Engineers Comments Regarding Surface Water Drainage

Application Reference:	WA/68/26/PL	Reviewer Reference:	ADC/EXT5/AF
Planning Officer:	Hebe Smith	Date of Review:	21/08/2026
Site Name:	The Greenway West Walberton Lane Walberton BN18 0QS		
Application Description:	Construction of a self-build/custom build single dwelling, with garage outbuilding and associated works. This is a departure from the local development plan and is in CIL Zone 3 and is CIL liable as a new dwelling.		
Assessment Number:	1

Drawing Title Topographic Land Survey

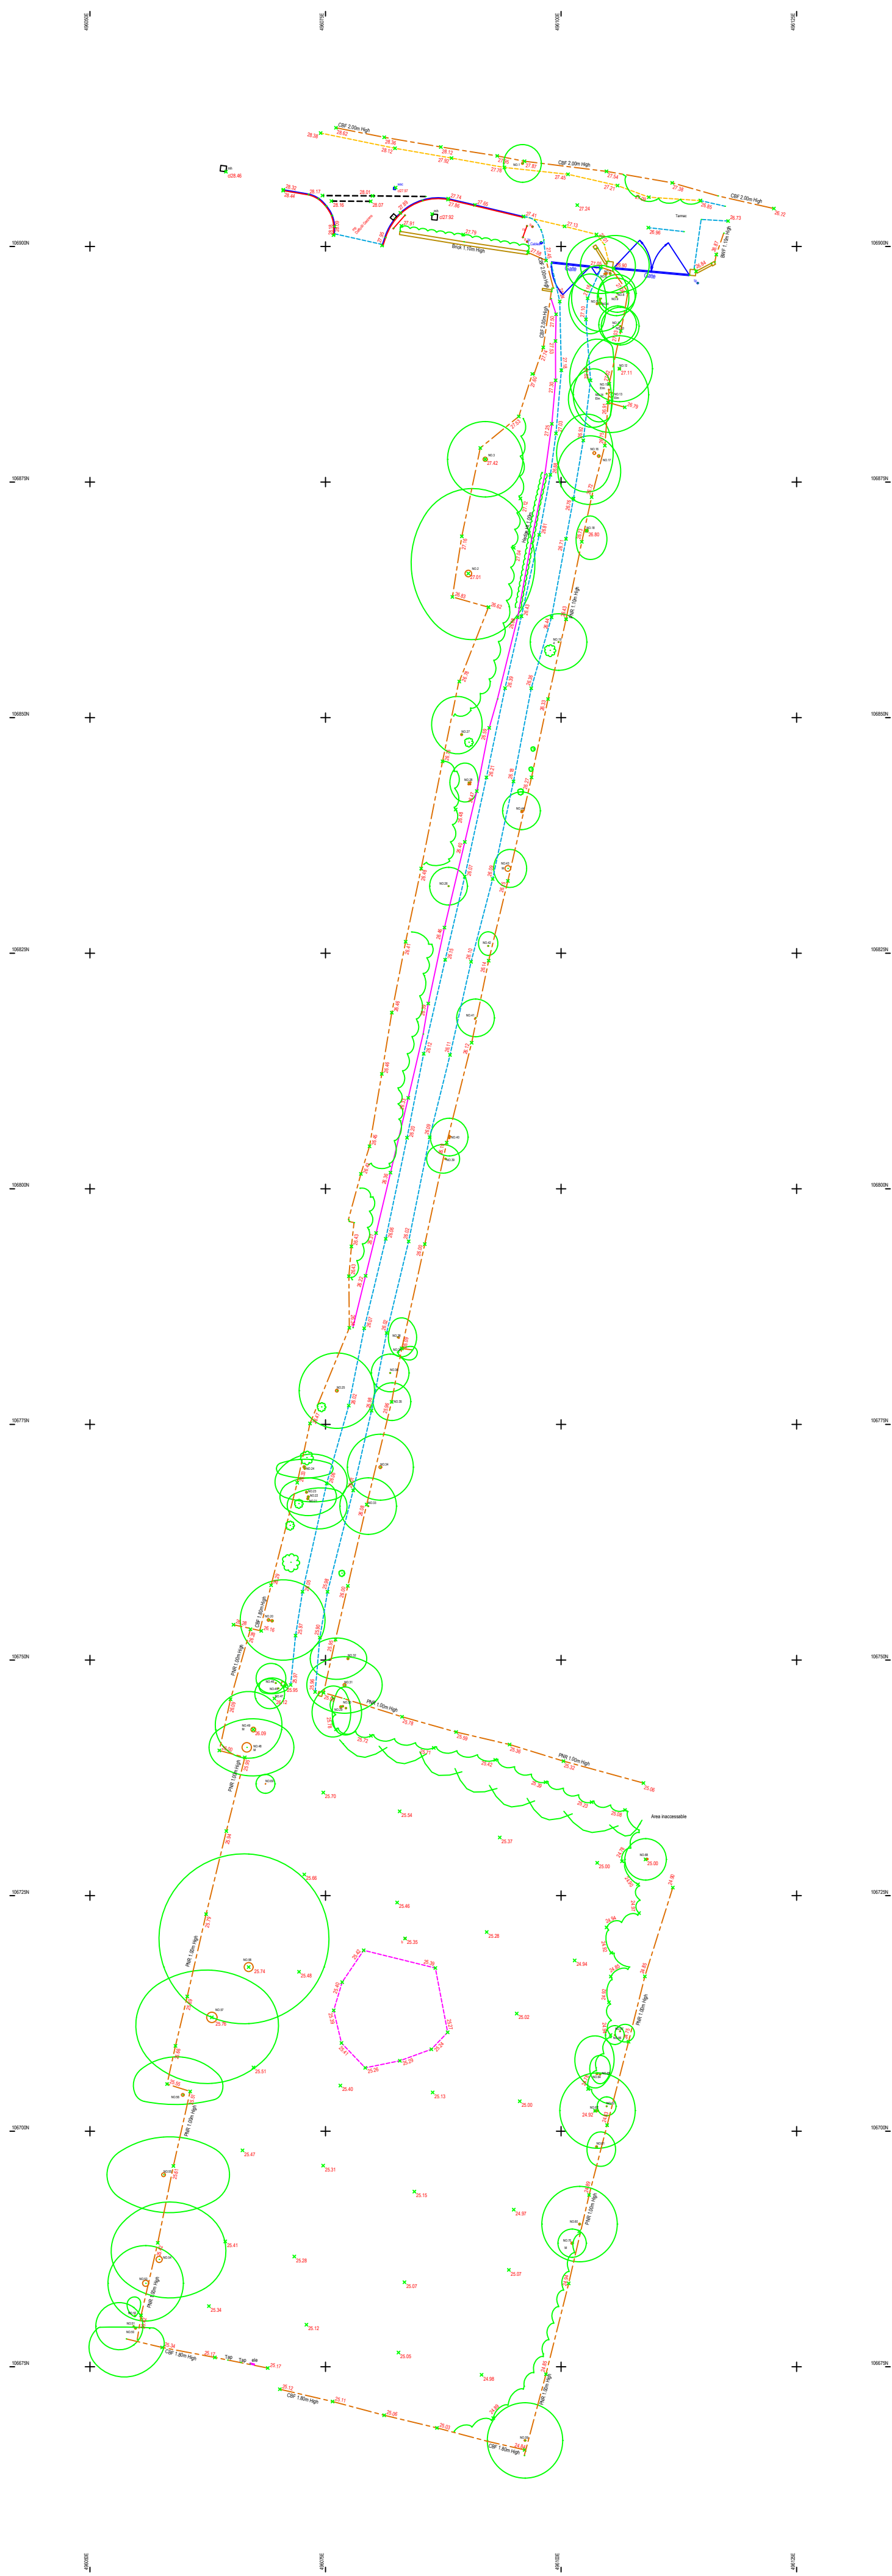
- 3.1. The FRADS includes drainage plans and modelling. The design is well progressed for planning stage.
- 3.2. The areas, base gradients, depths and effective storage depths of permeable paving is not clear from the calculation outputs. Evidence of drainage model inputs should be provided.
- 3.3. Clarification is required as to how the permeable driveway with existing trees is designed and included in the drainage calculations in terms of how the storm water will be stored whilst retaining root protection / 'no dig' construction, including permeable paving base gradient. Proposed base levels should be shown in comparison with the topographic survey together with a total thickness of construction.

- 3.4. In addition, the infiltration testing was carried out at a depth of 1m below ground level and there is no evidence that the necessarily shallow base level of no dig construction will achieve the same infiltration rate. The runoff from the driveway may add to the drained area in the parking and turning area and may pond or flood from the low point.
- 3.5. The design to manage extreme rainfall is not currently demonstrated to be in accordance with the requirements of NSfS Standard 3. Therefore, we **object** to the application.

Land north of The Green Way
Appendix 6 - tree protection plan

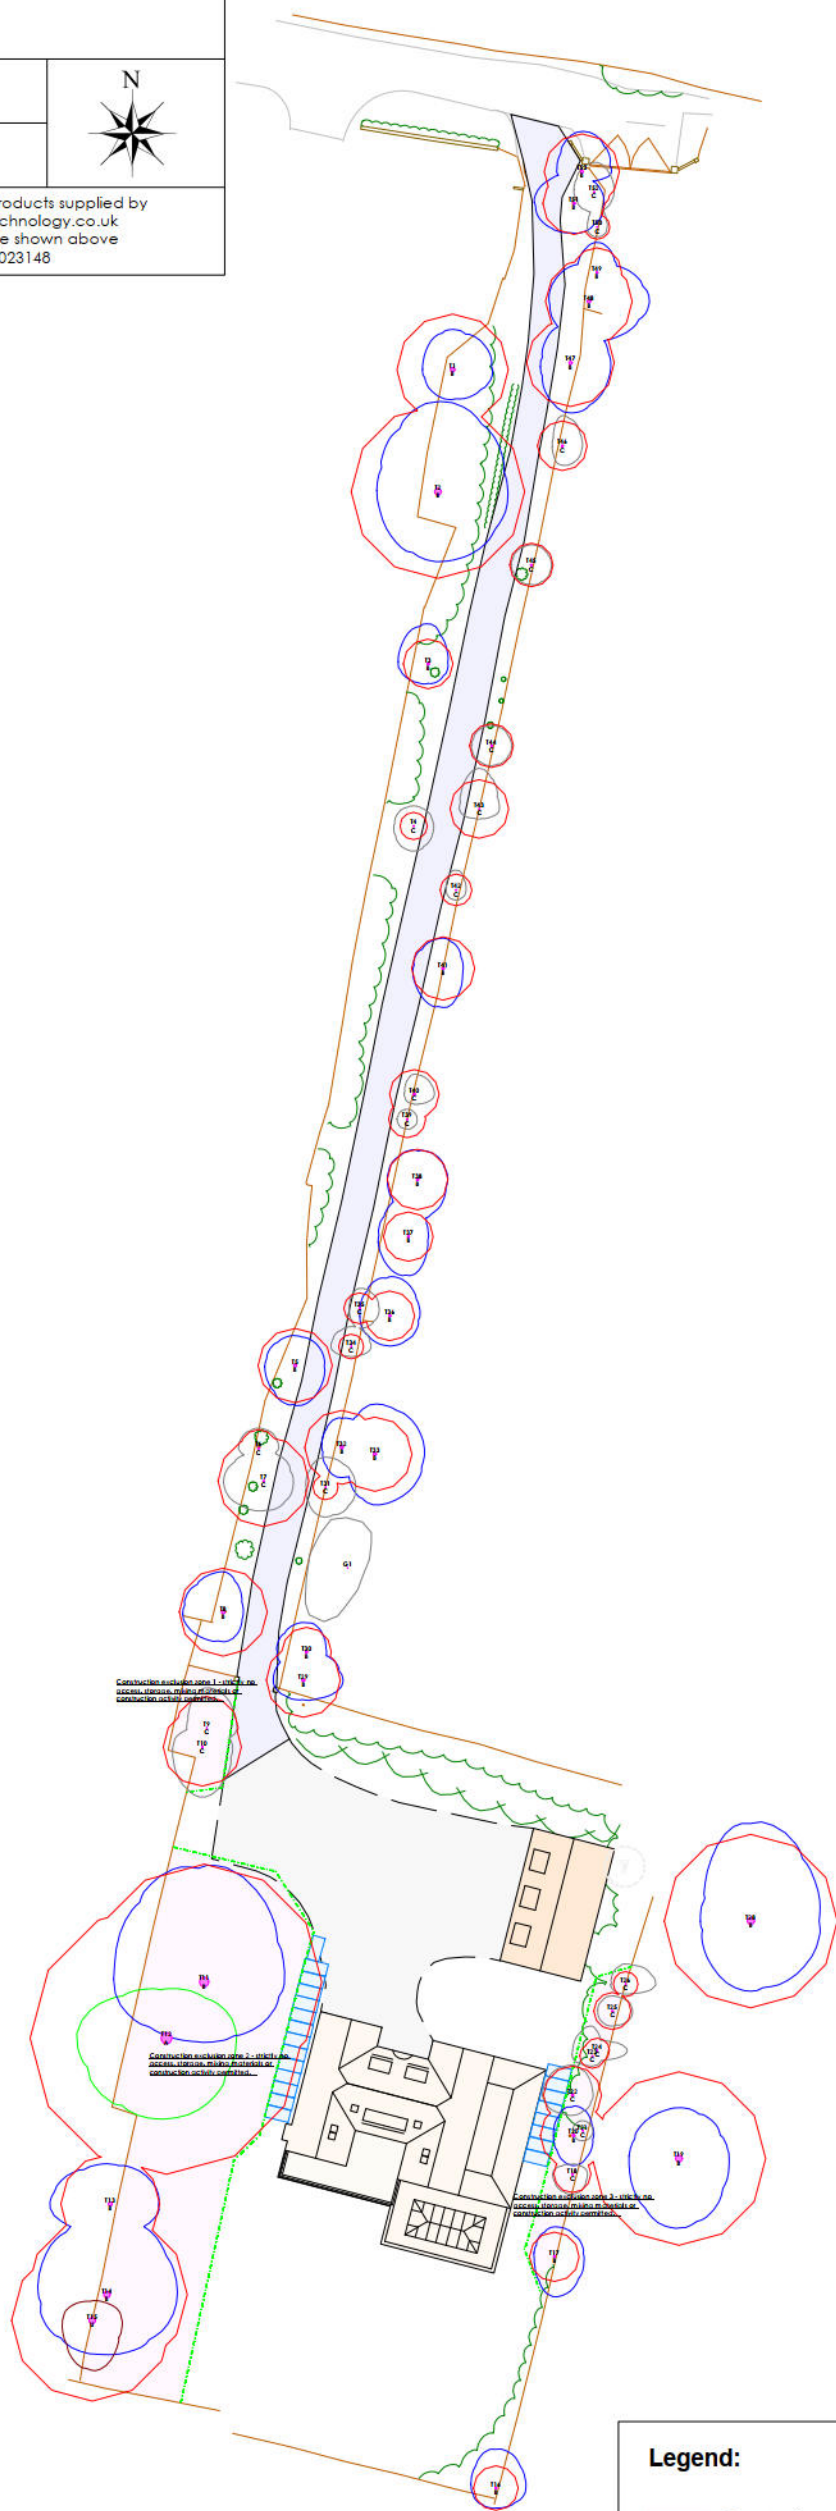
- 0.5. The existing trees adjacent to the access drive have root protection areas that requires root protection / 'no dig' construction.
- 0.6. The application is supported by a Flood Risk Assessment and Drainage Strategy [FRADS] which is updated following our comments on the previous application.

- 7.1. An outline maintenance plan is provided which is proportionate to the scale and nature of development as the dwelling will be in a single ownership.
- 7.2. There are a significant number of good quality trees on the site, most of which are to be retained. These existing trees are a constraint to the drainage strategy as any drainage installations should not damage the trees, and the drainage infrastructure itself needs to be protected from tree root damage. The design as submitted demonstrates areas of conflict with the existing trees and their current root protection areas which will require root protection construction methods. Further information is required to demonstrate the design is feasible.
